Development Facilitation Team (DFT) – Review Comments

DRB Project No: PR-2020-003484 Date: 2/12/2025 Agenda Item: #3 Zone Atlas Page: E-10

Request: Replat of Lots 2 and 3 – create 19 lots from the existing tracts.

Application For: SD-2024-00158 – EXTENSION OF PRELIMINARY PLAT (DHO)

NEW EASEMENTS

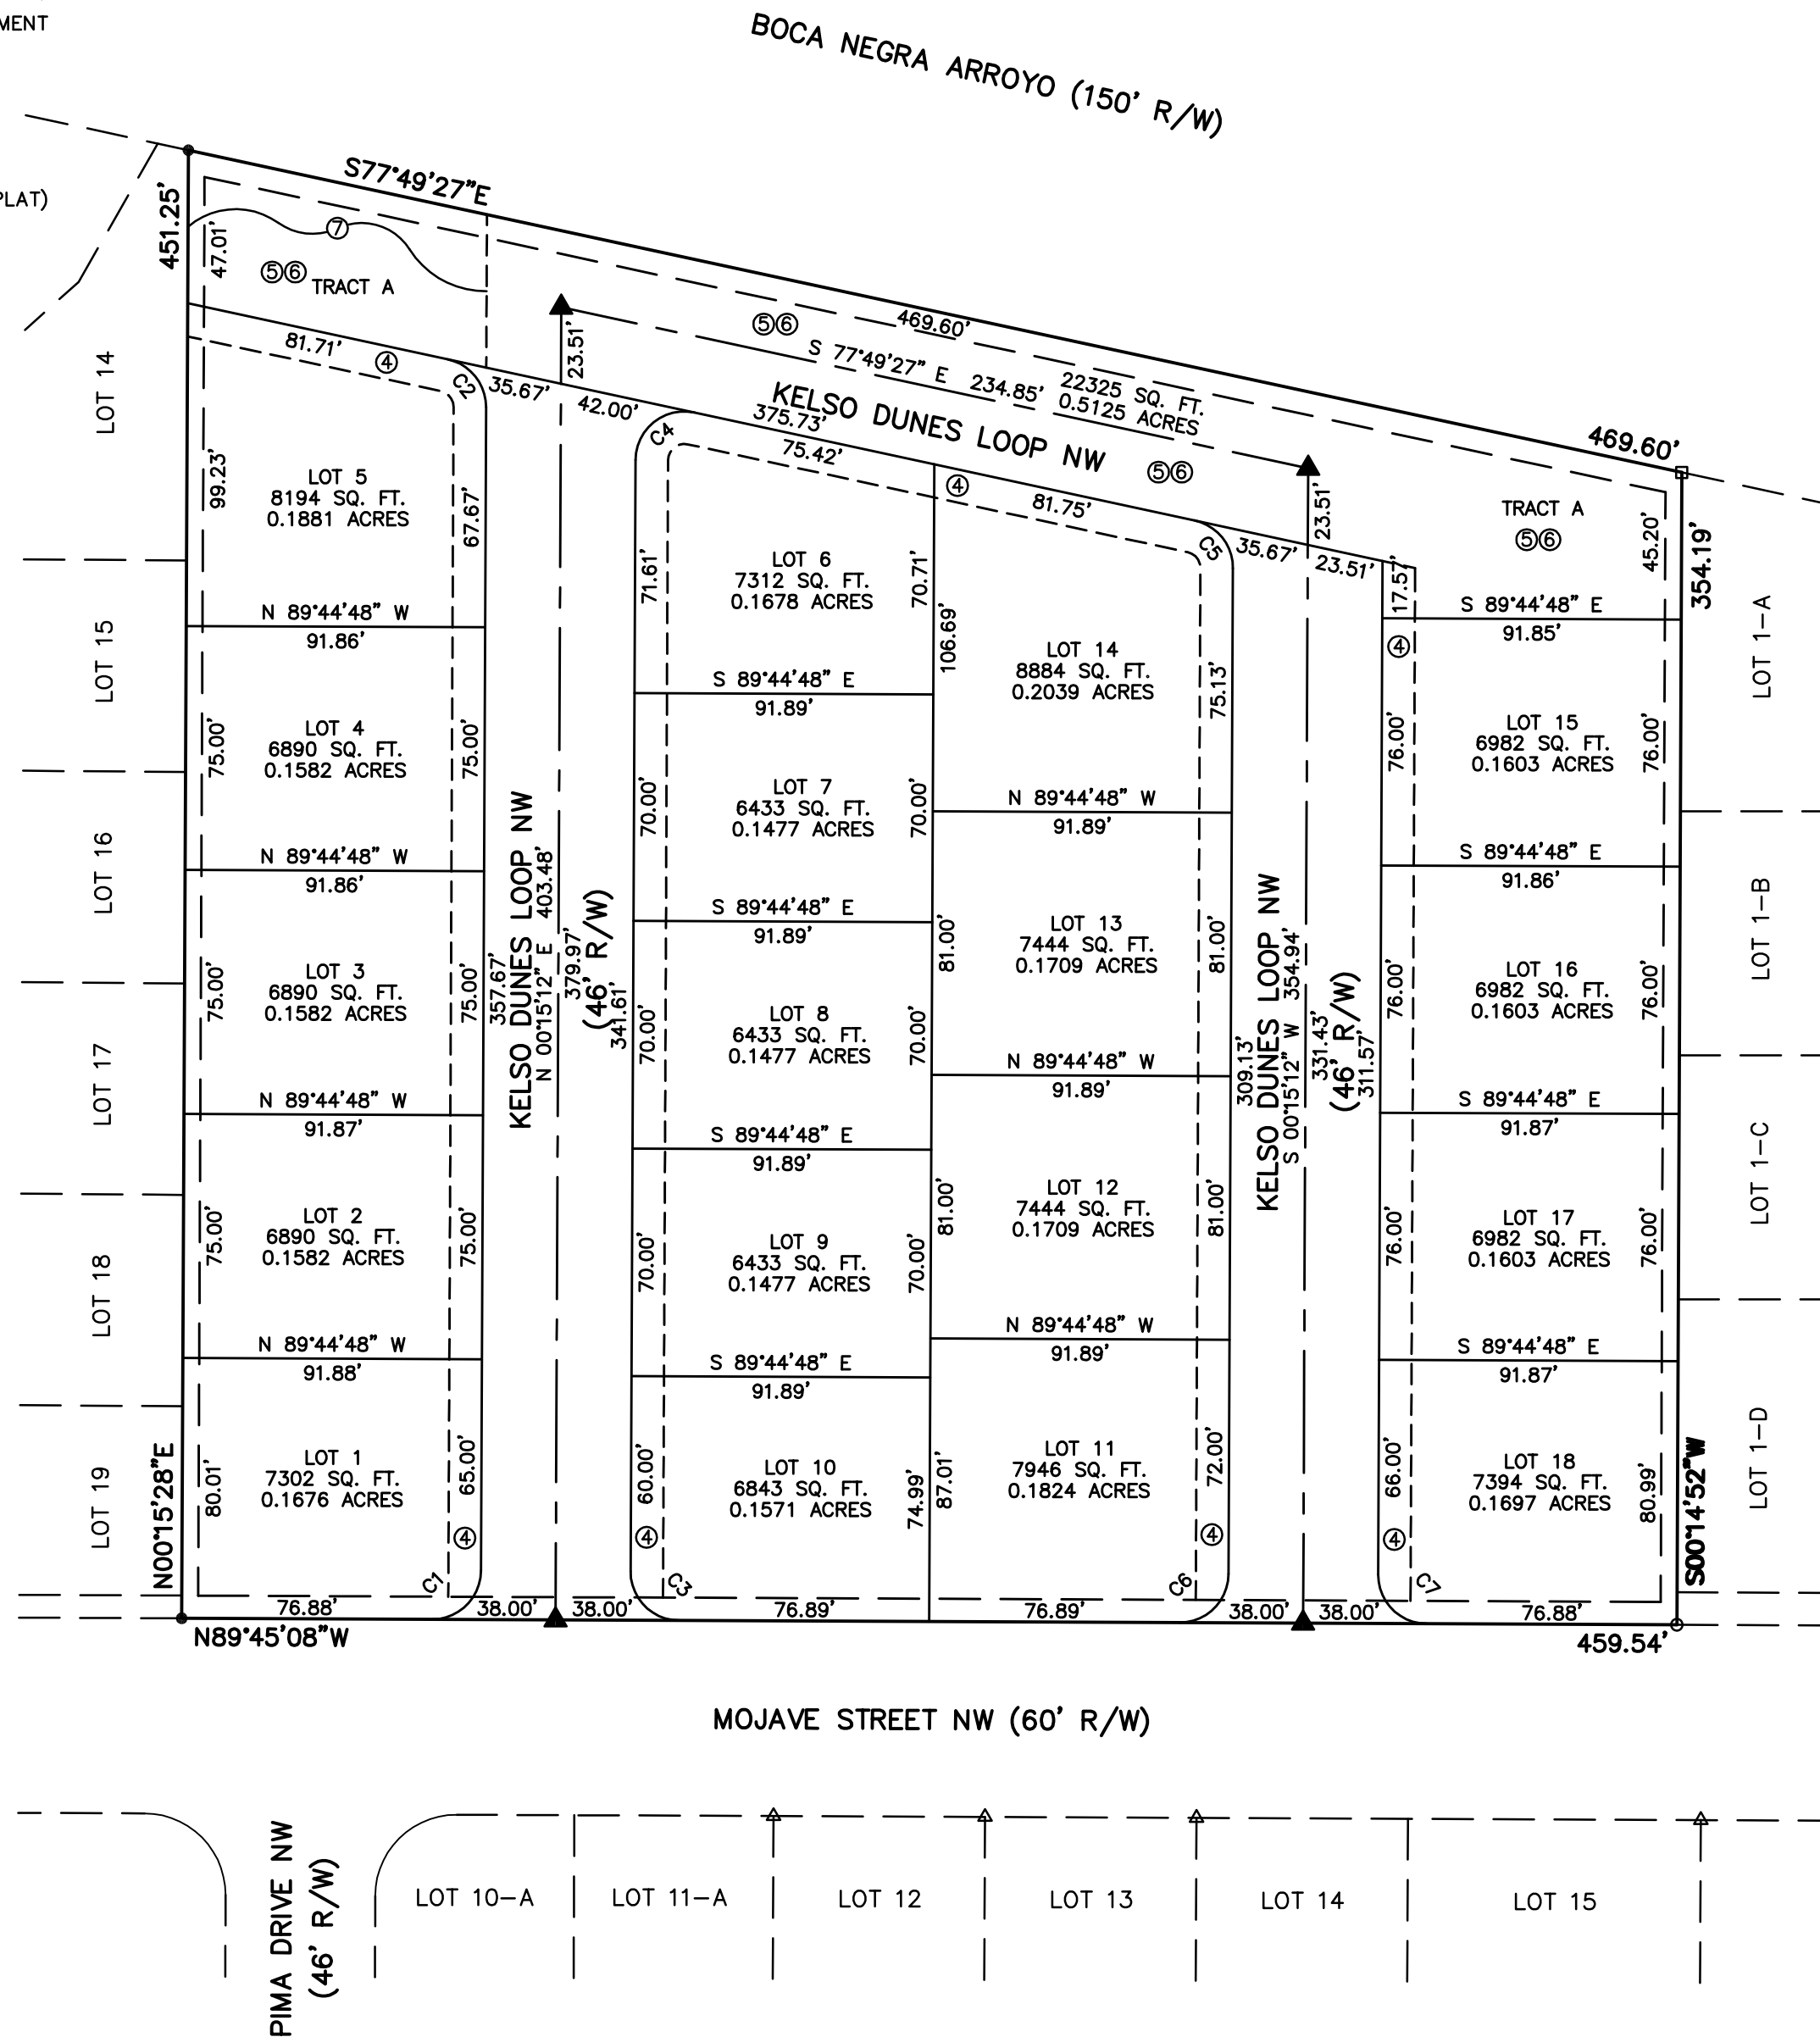
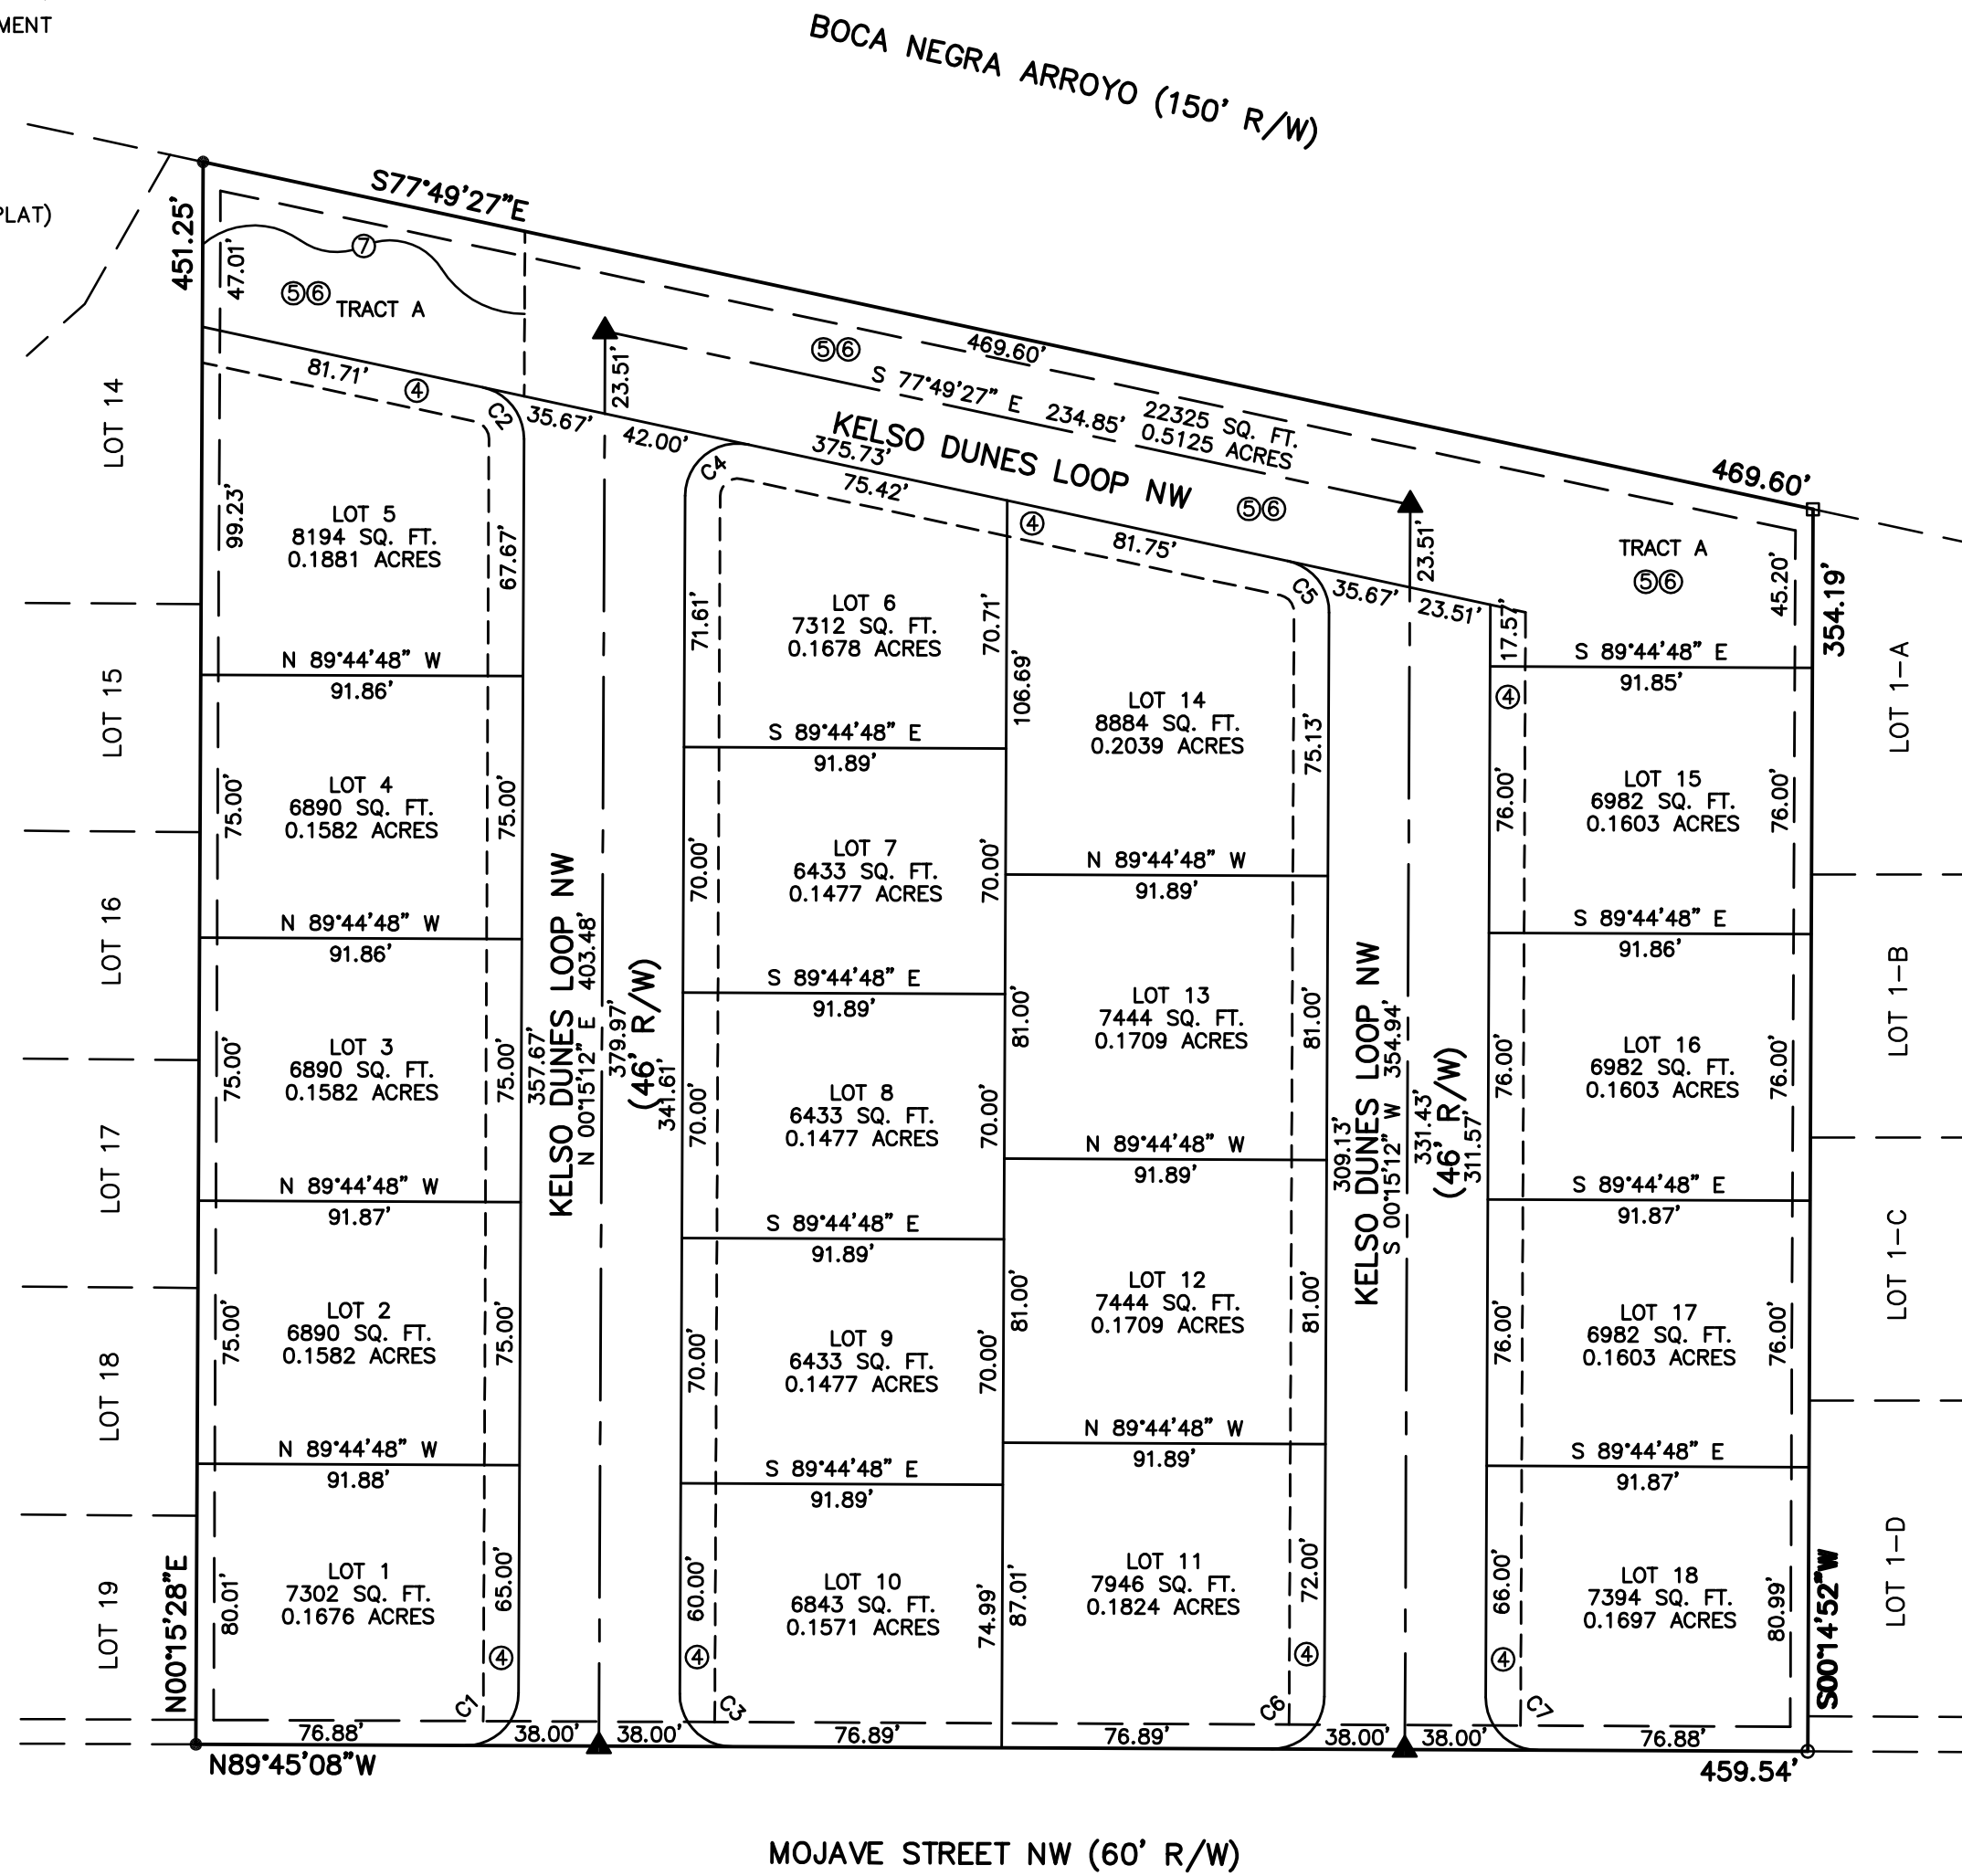
Please note on the plat that the Boca Negra Arroyo parcel is zoned NR-PO-B Major Public Open Space/Petroglyph National Monument. This helps staff identify standards that will be required when the site is developed.

Please note on the plat the **45' landscape buffer** required on Tract A due to adjacency to MPOS – No development is allowed and plant species and location must be approved by the Open Space Superintendent.

- ✓ Per Parks and Recreation: Add note on the plat that the parcel adjacent to the subject site "Boca Negra Arroyo (150' R/W)" is zoned NR-PO-B for MAJOR PUBLIC OPEN SPACE - PETROGLYPH NATIONAL MONUMENT.
